Sterling Ranch Comment Response Letter

RE: Sterling Ranch Comments - SF-17-025 - Homestead at Sterling Ranch Filing No. 1.

Enclosed are the response to comments provided by El Paso County Development Services Department on the Sterling Ranch Project; SF-17-025 – Homestead at Sterling Ranch Filing No. 1, Second Submittal

FINAL PLAT
HOMESTEAD AT STERLING RANCH
FILING NO. 1
JOB NO. 09-005
DATE PREPARED: 10/30/2017
DATE REVISED: 07/30/2018

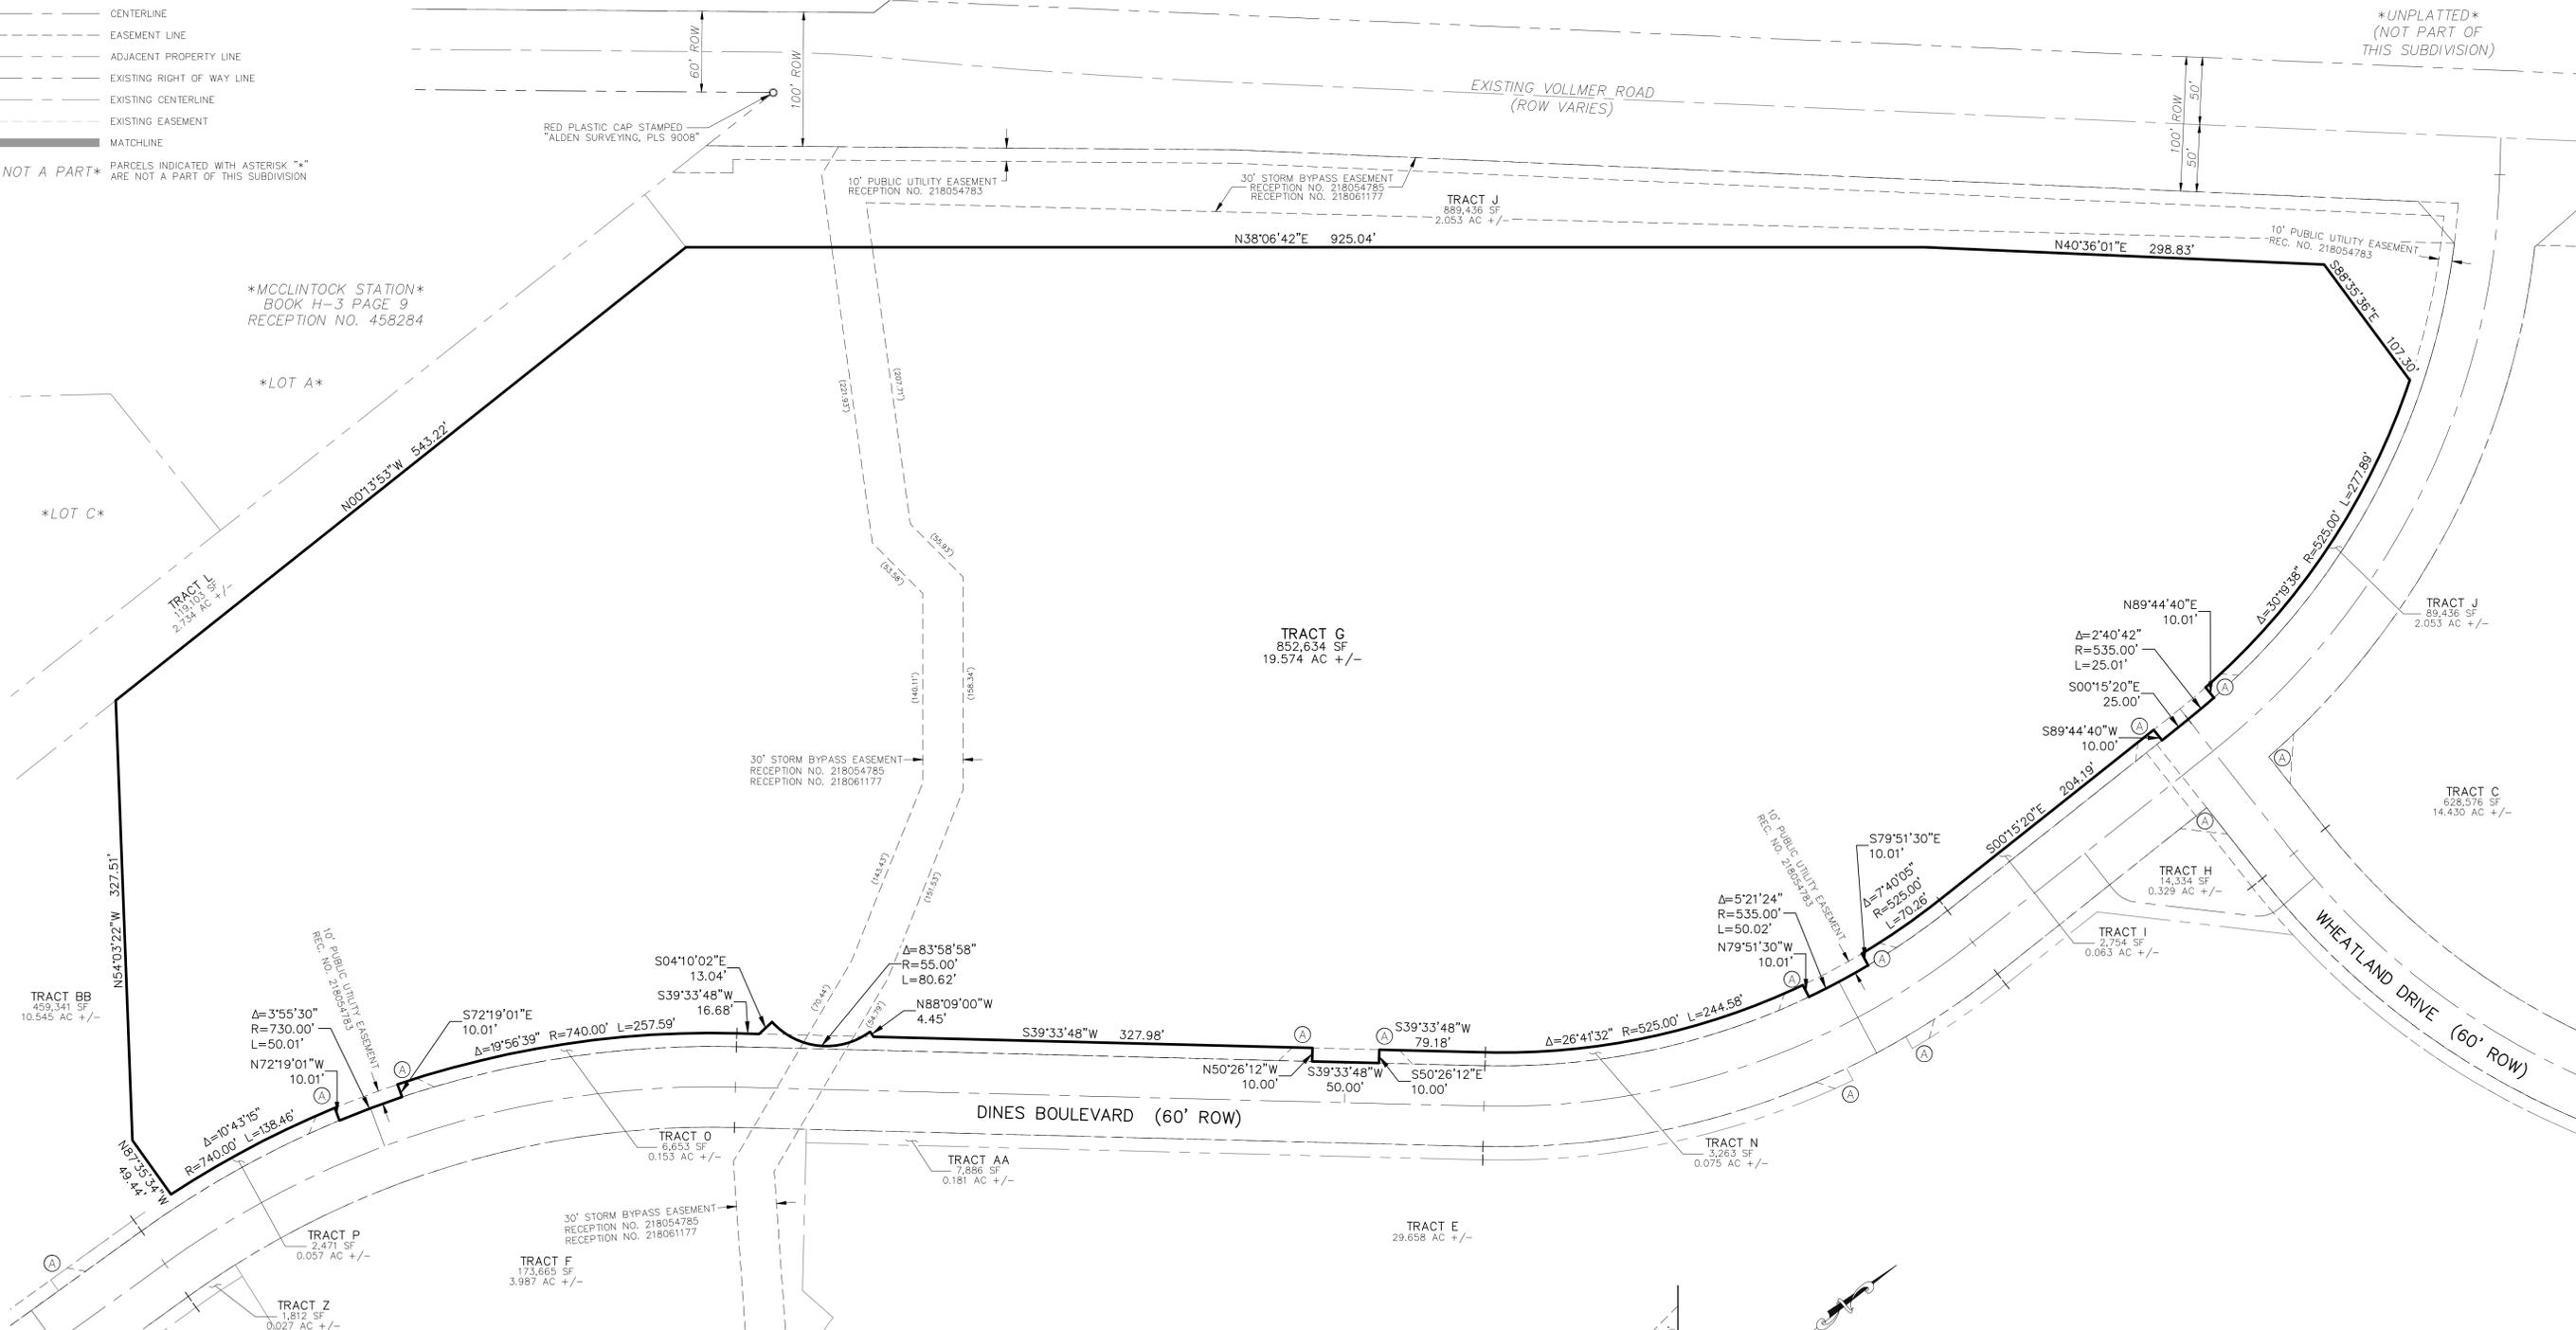
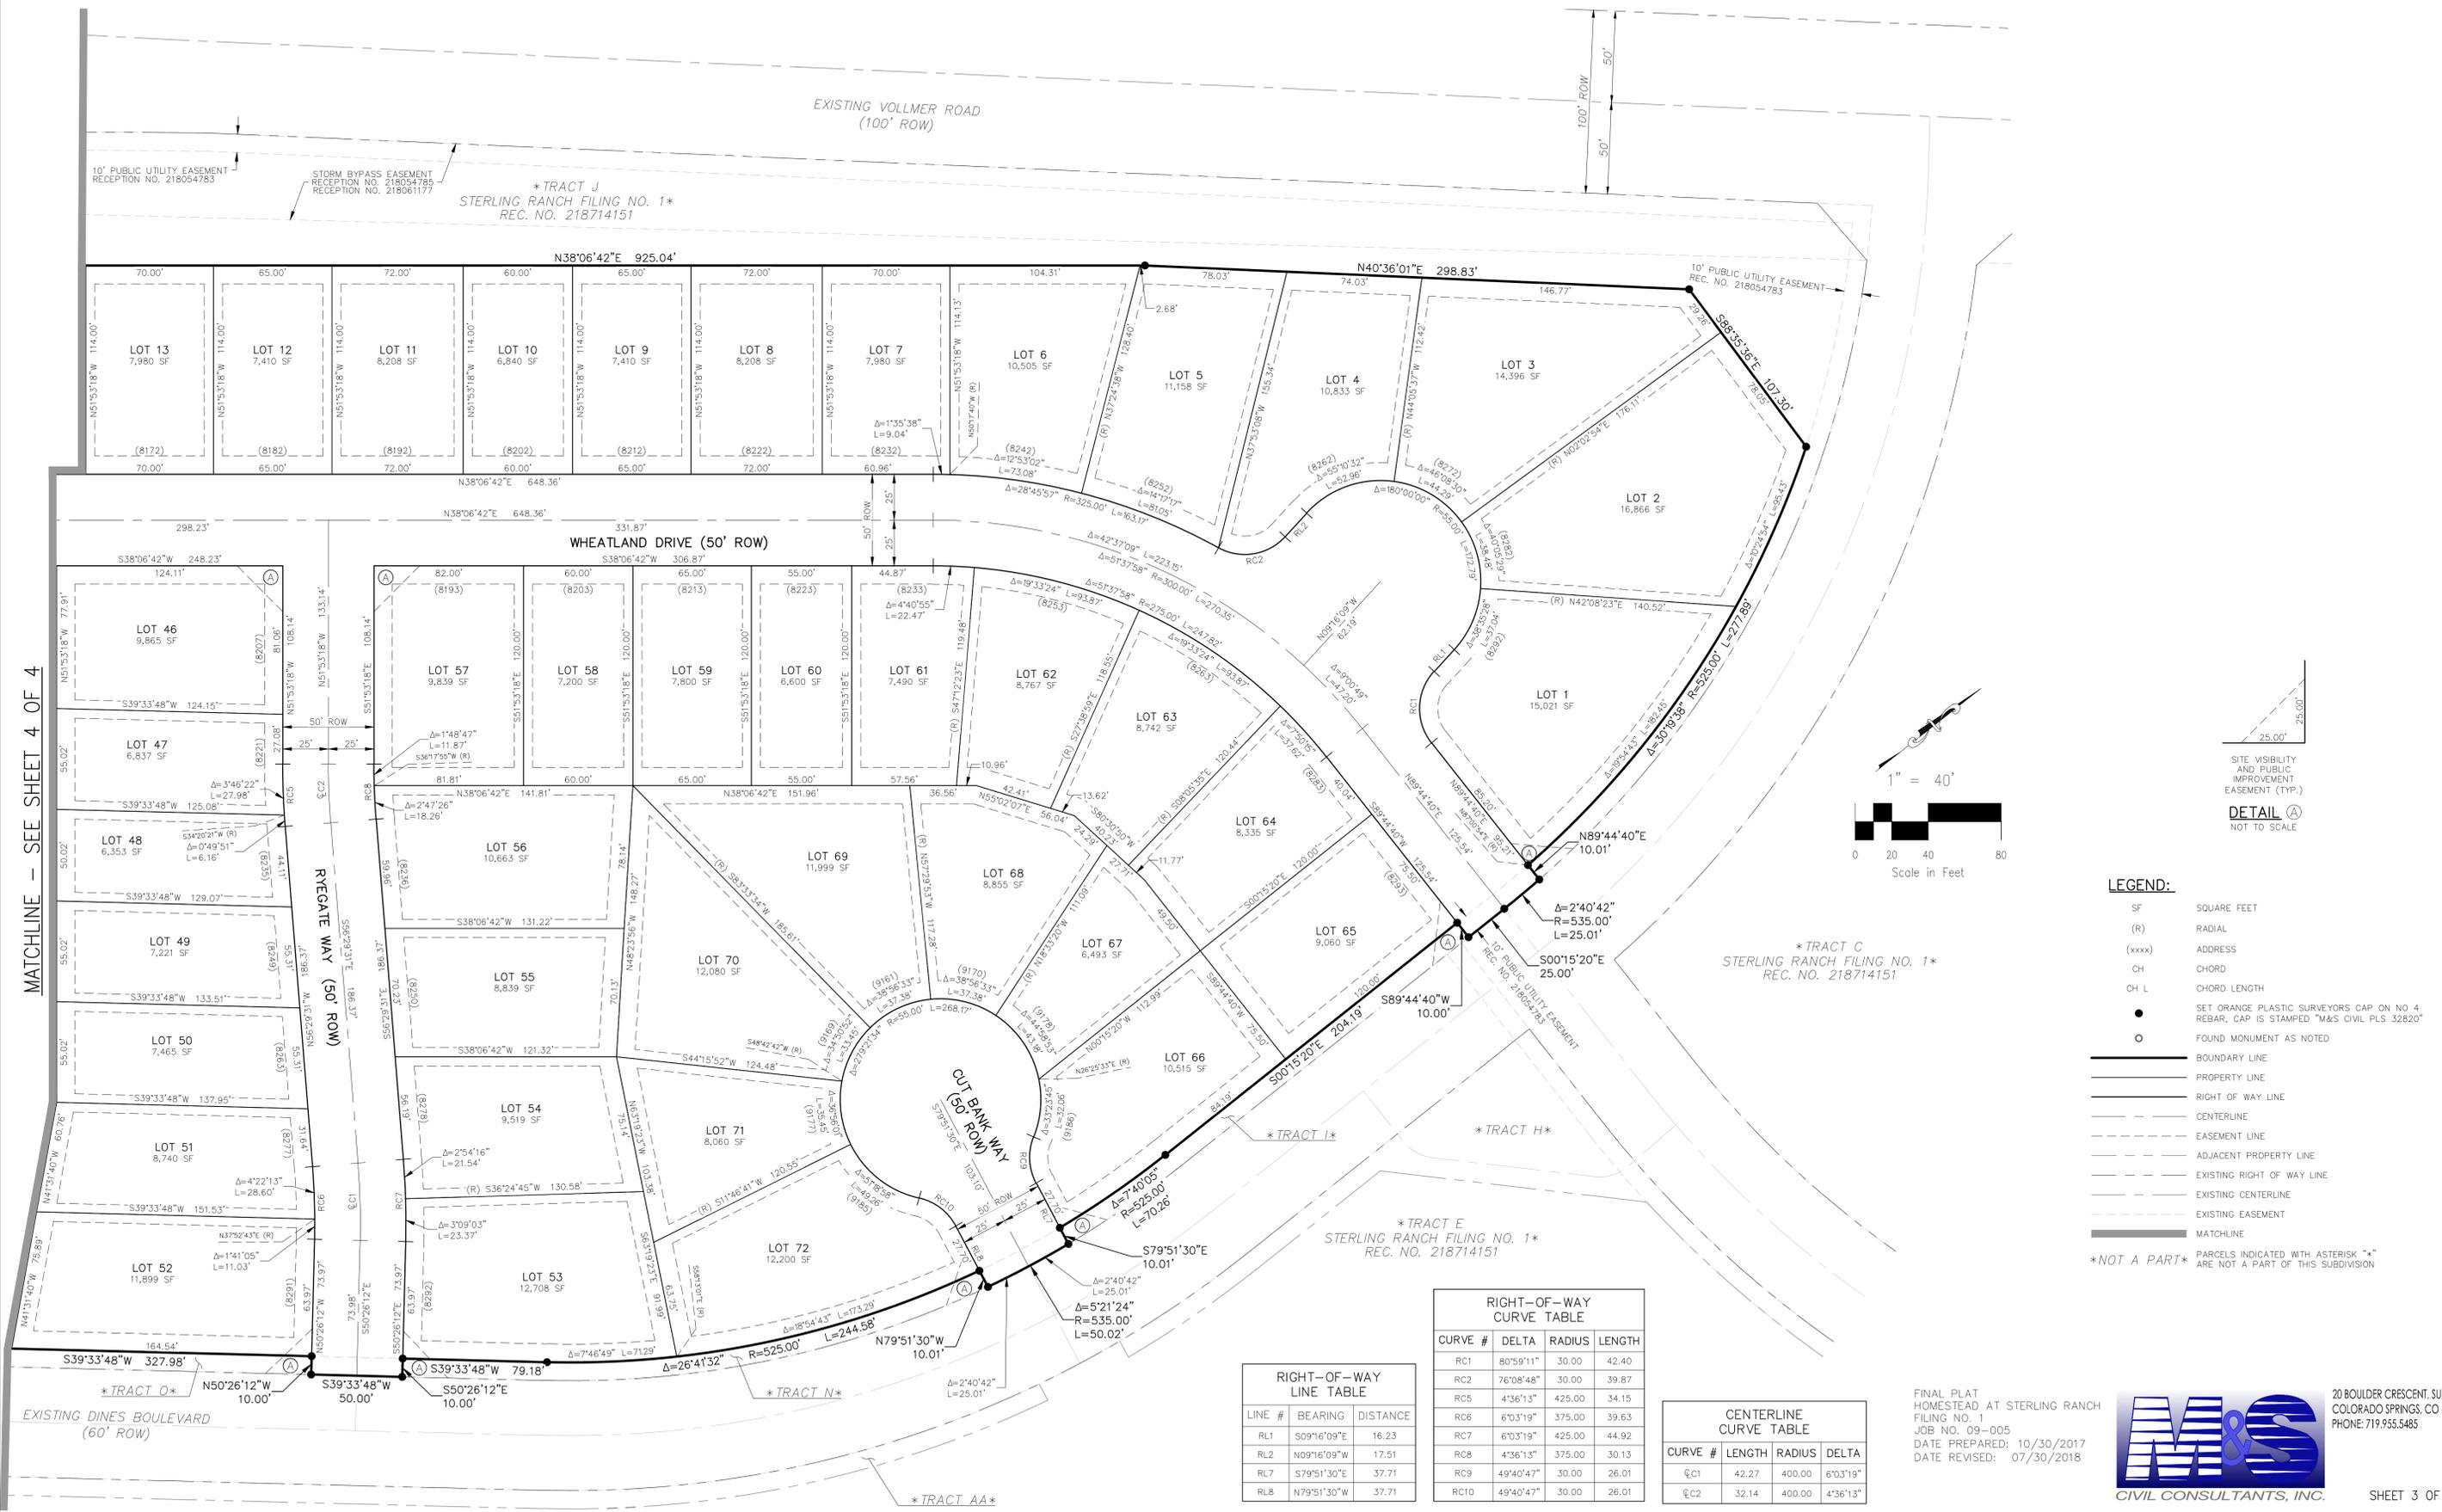
1. **Resolved**
2. See Final Plat redlines for cursory comments. **Partially resolved; see updated redlines.**
Noted.
3. **Resolved**
